# SITE DEVELOPMENT PLAN

## for BUNTING MULTIFAMILY FILING NO. 1, EL PASO COUNTY, COLORADO

BUNTING MULTIFAMILY  
SITE DEVELOPMENT PLAN

# Markup Summary

COVER SHEET

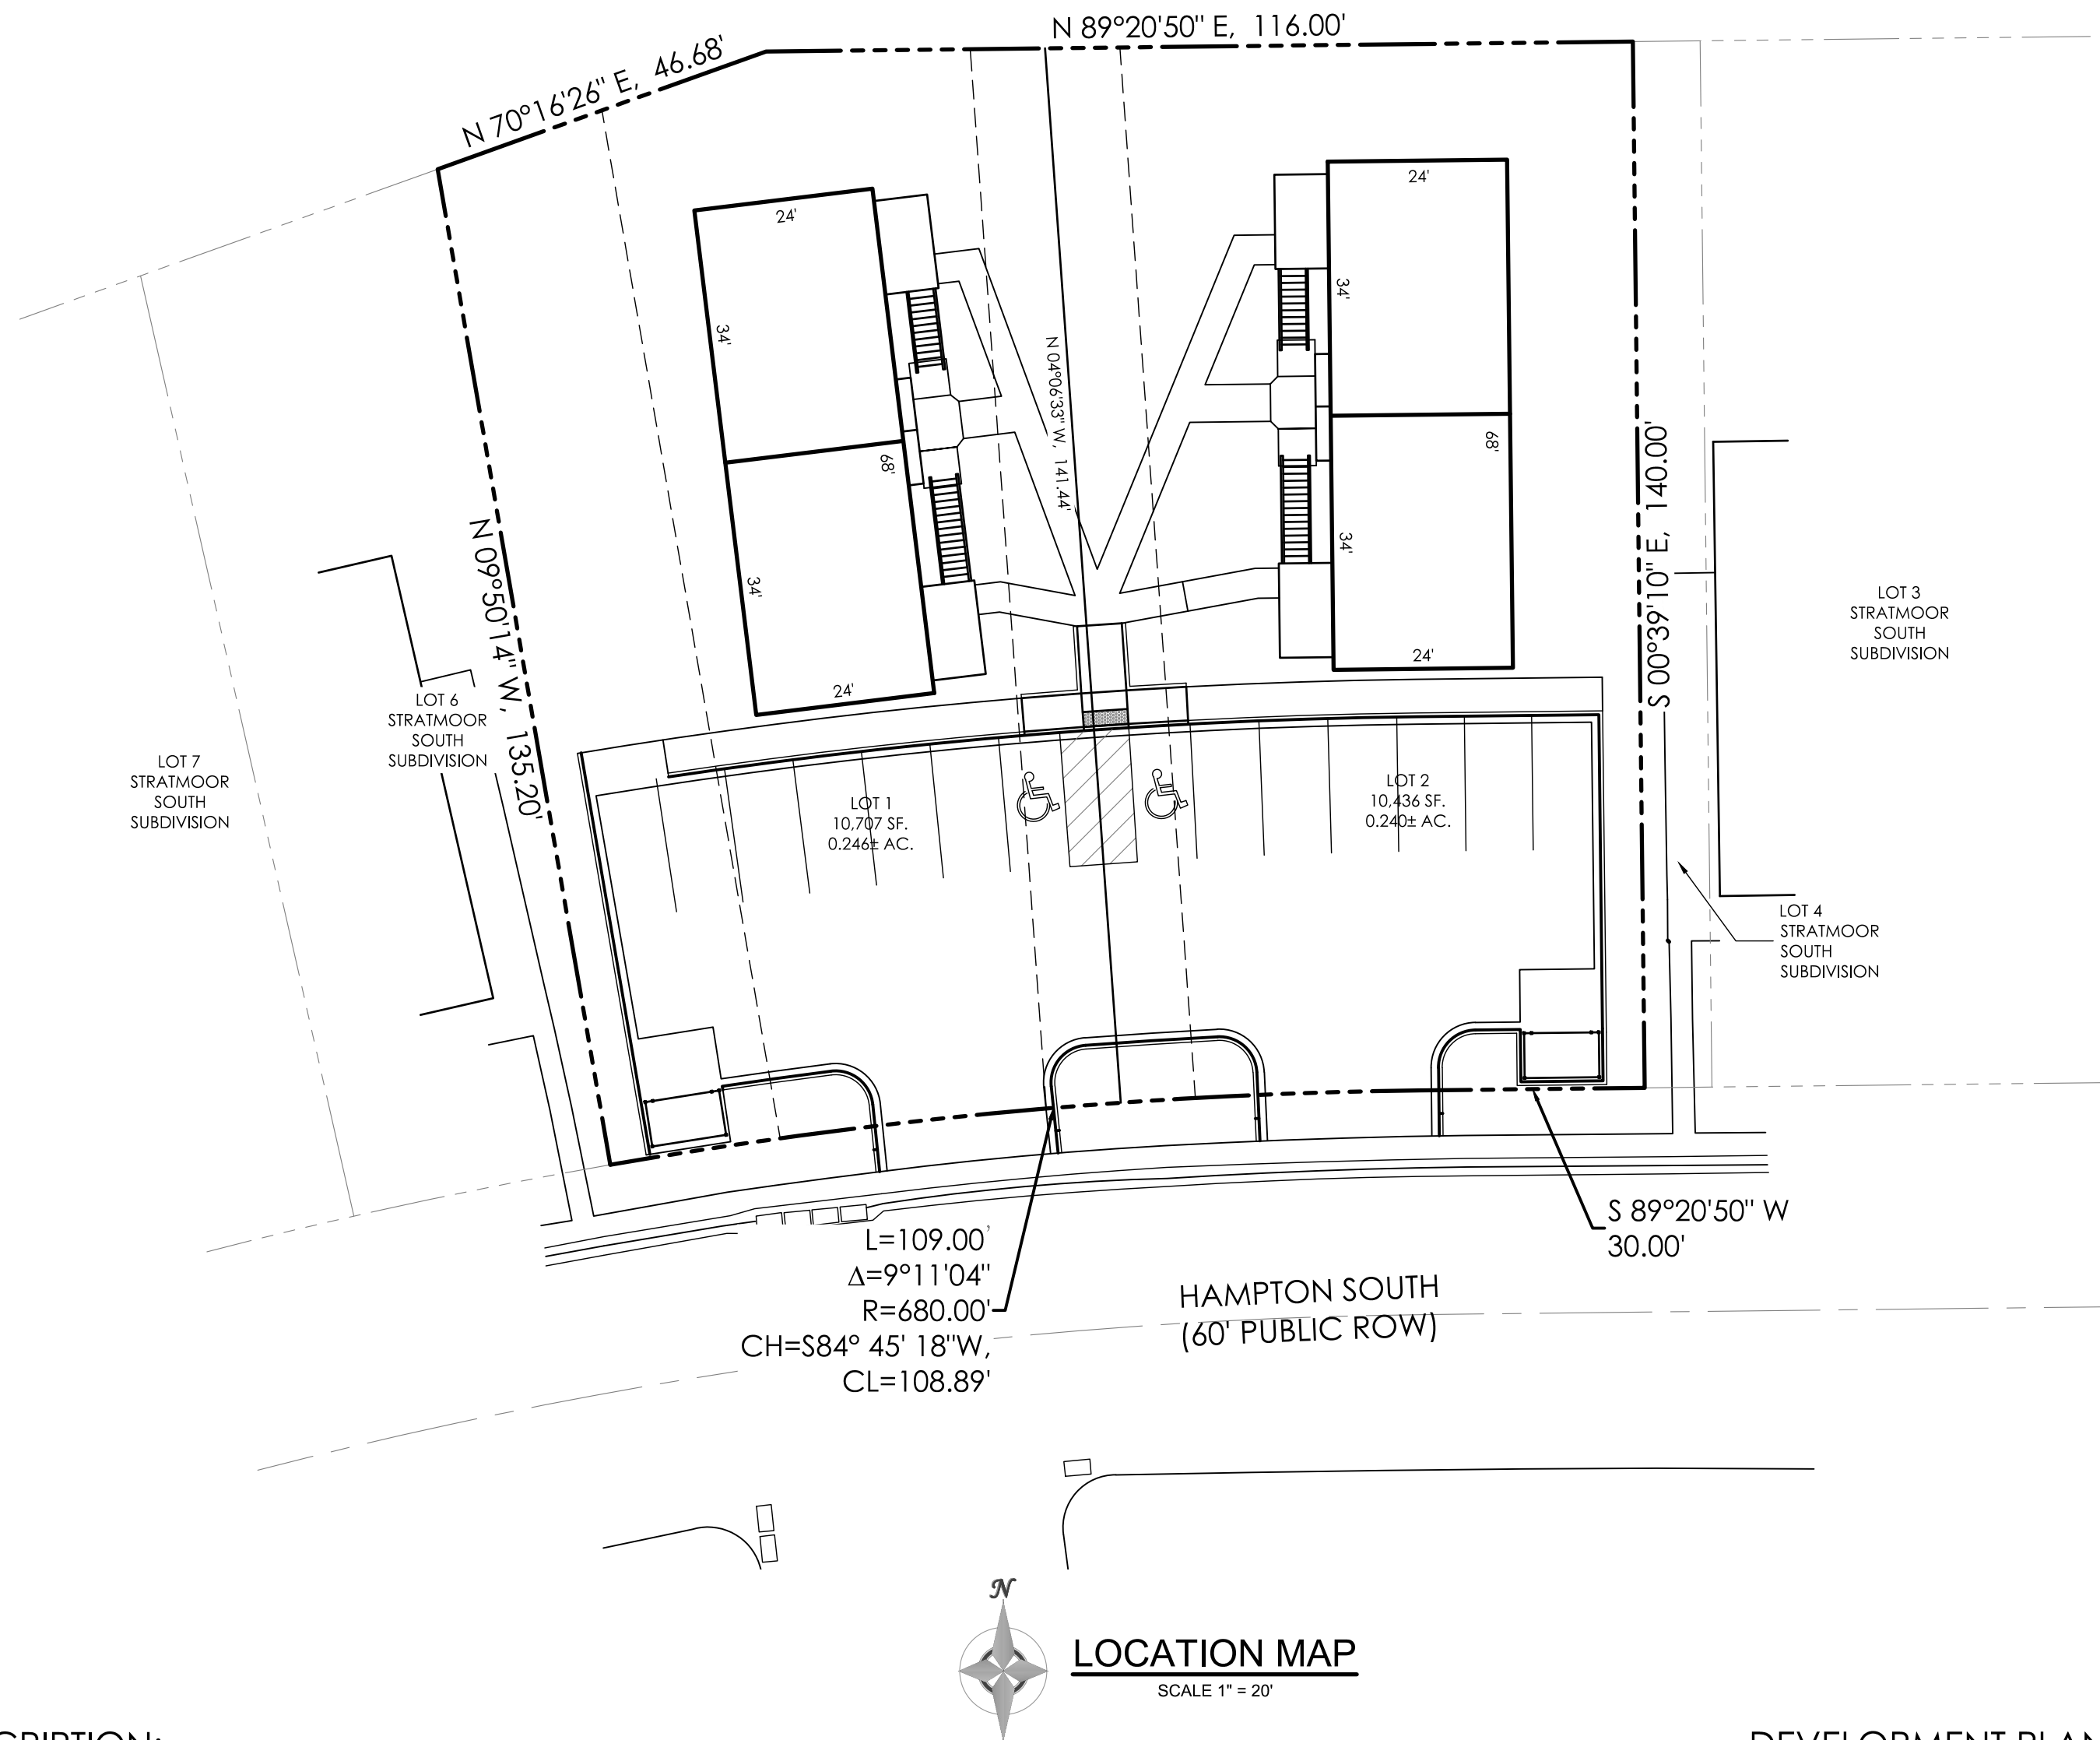
Add a grading plan for the proposed grading.

Should the request for administrative relief be denied, the plans will need to be revised to meet the setback and parking requirement.

SITE PLAN

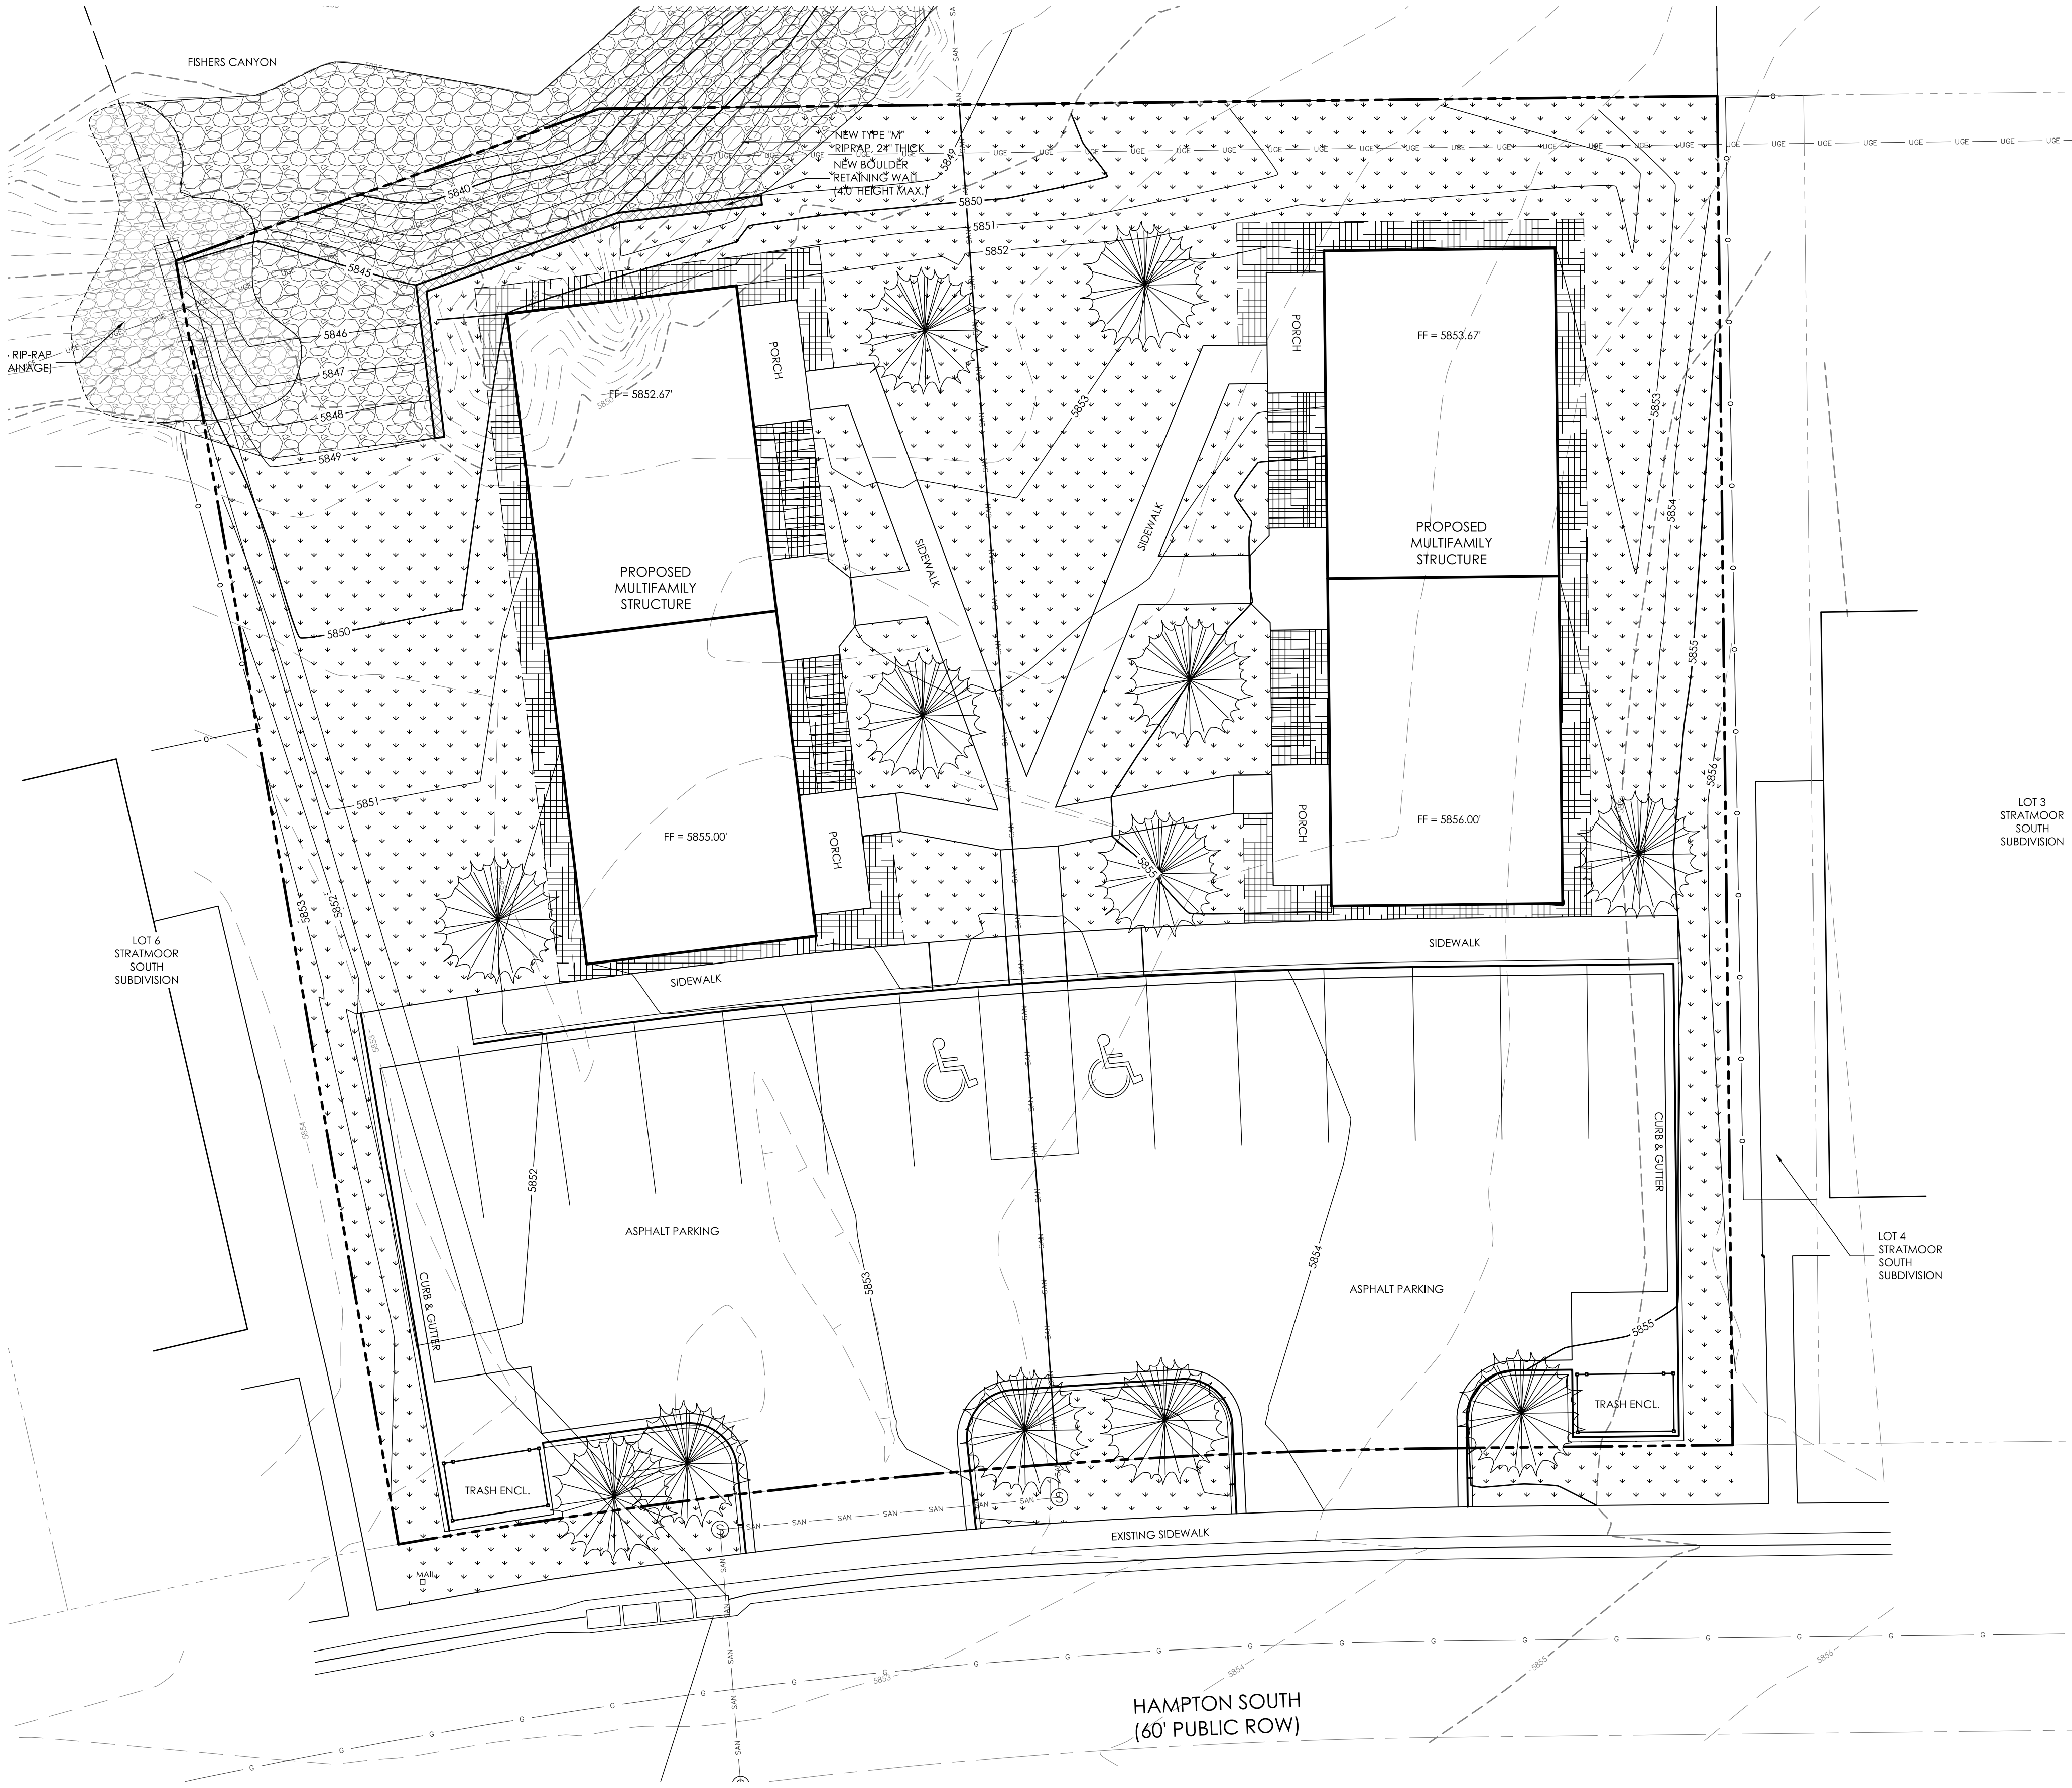
Label Fisher's Canyon and show the 100yr floodplain boundary

Show proposed grading contours on a separate grading plan.

While an ESQCP is not required, the applicant must obtain a BESQCP prior to construction.

Include the manhole in the legend.  
Show the pipe layout.  
This appeared to be sanitary sewer with an incoming line from the northwest. An easement may need to be placed along the line if it's a service line for Lot 6 in case it needs to be repaired/replaced.

Show the incoming and outgoing pipe for the inlet.  
According to the County GIS (attached), the stormline goes through Lot 2 and outfalls.

This appears to be a fill area. Will there be a retaining wall at the back of the lot. On the grading plan identify the 100yr WSEL.

Identify the Finished Floor Elevation for both buildings on the grading plan

Applicant must field verify the actual storm drain location. The plat must include an easement along the stormdrain line.

Will someone be able to back out of this space with the curb and gutter?

These porches may not be covered, otherwise they do not meet the setback requirements.
